City of Albuquerque Stormwater Construction Site Inspection Report

ESC File No.	M21E018_1	Project Name:	Volterra - Juan Tabo Hills		
NPDES Id. No.	NMIR1003LU	Location:	11404 Rock Squirrel Ave SE		
11/19/2021	Owner		Contractor		
Operator	Twilight Homes				
Contact name & title	Tim Mcnaney				
e-mail	tmcnane@twilighthomesnm.com				
Contact Phone #	505-975-1154				
COA Inspector	James Hughes		Start/End Time:	11:00am	
Construction Phase:	Vertical				
Type of Inspection:		Storm Event	Past Storm Event >0.25"	311/Complaint	Follow Up
Weather at time of inspection?	clear		Temperature: ~	39	
Estimated date of last storm 0.25" or greater	10/17/2021

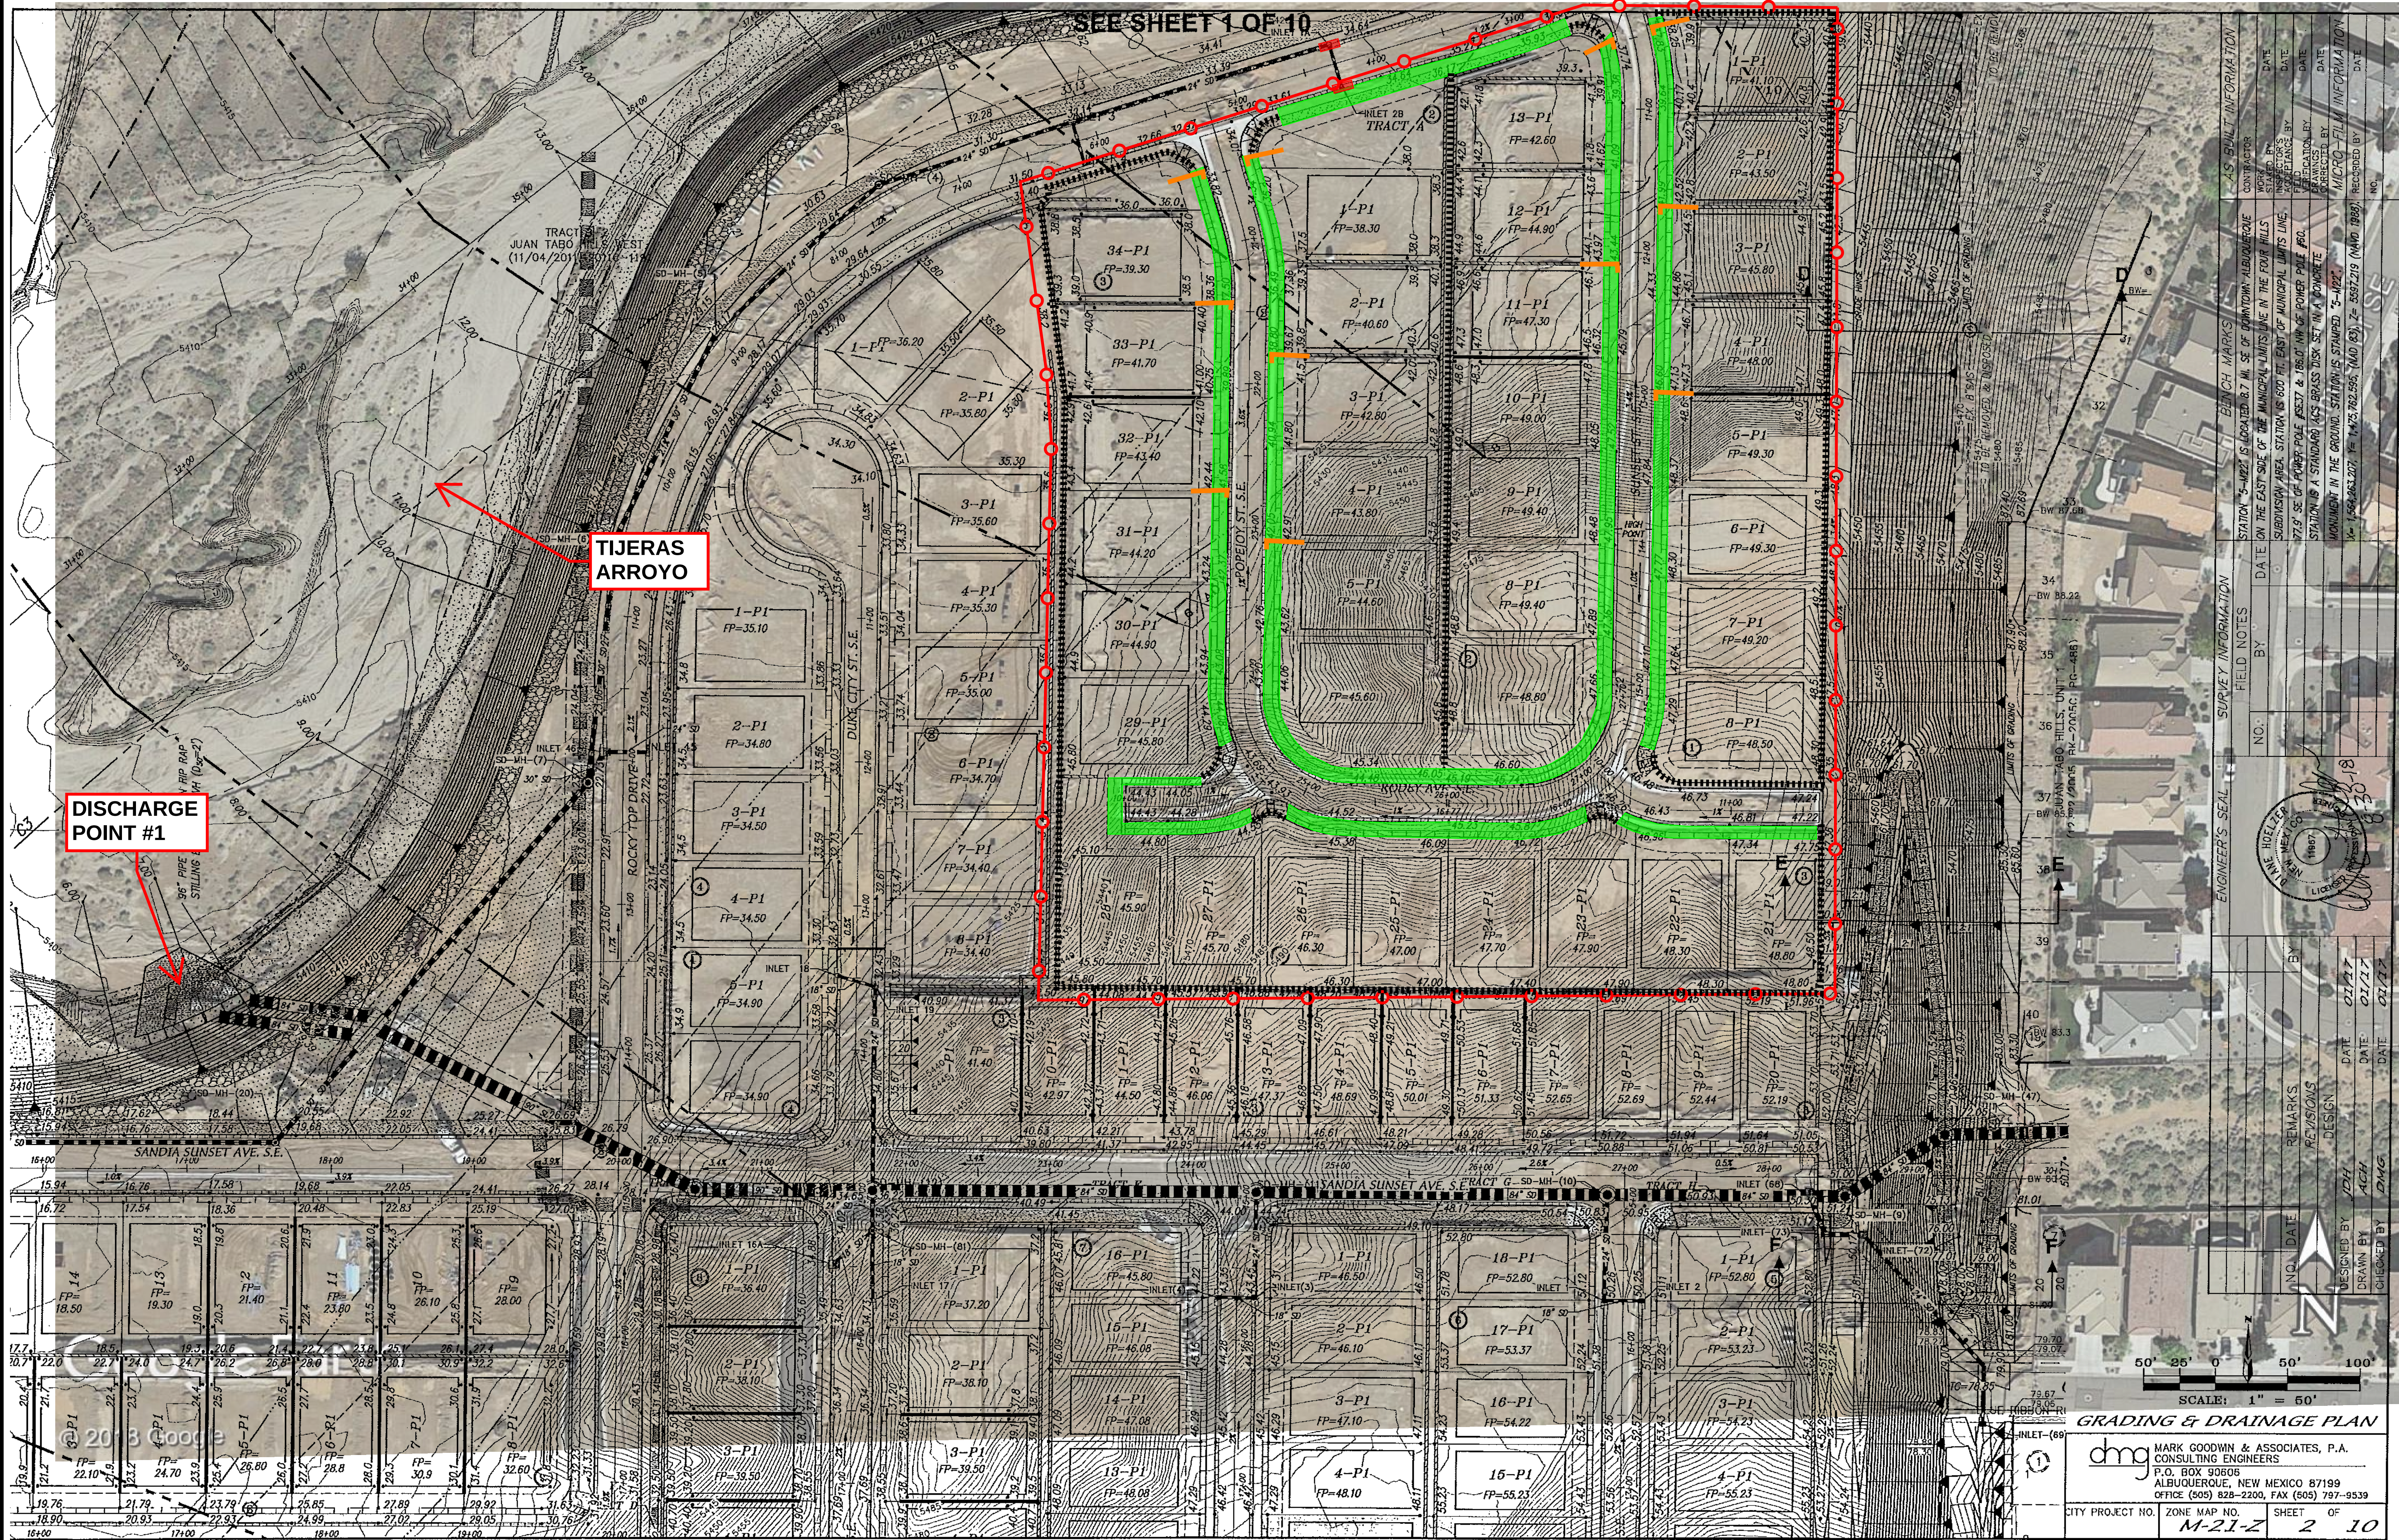
Item Number	Deficiency/ Corrective Action				
1	Washout on lots on lots on lobo trout and running bear.				
2	Sediment build-up at inlets on Running Bear. Remove sediment from inlets and ensure mulch socks are properly positioned. So they don't prevent drainage into the inlets (bags on either side, not in front.)				
3	SWPPP not up-to-date. (Sold lots and IP not on map, Operator Certification not signed, Operator signature missing from reports and reports not current, Delegations of authority don't meet requirements of CGP App 'l.11')				
4					
2.1	Discharge off site? (Y/N)	no			
4	Self Inspection Reports	Requested	Latest report Date:	4/7/2021
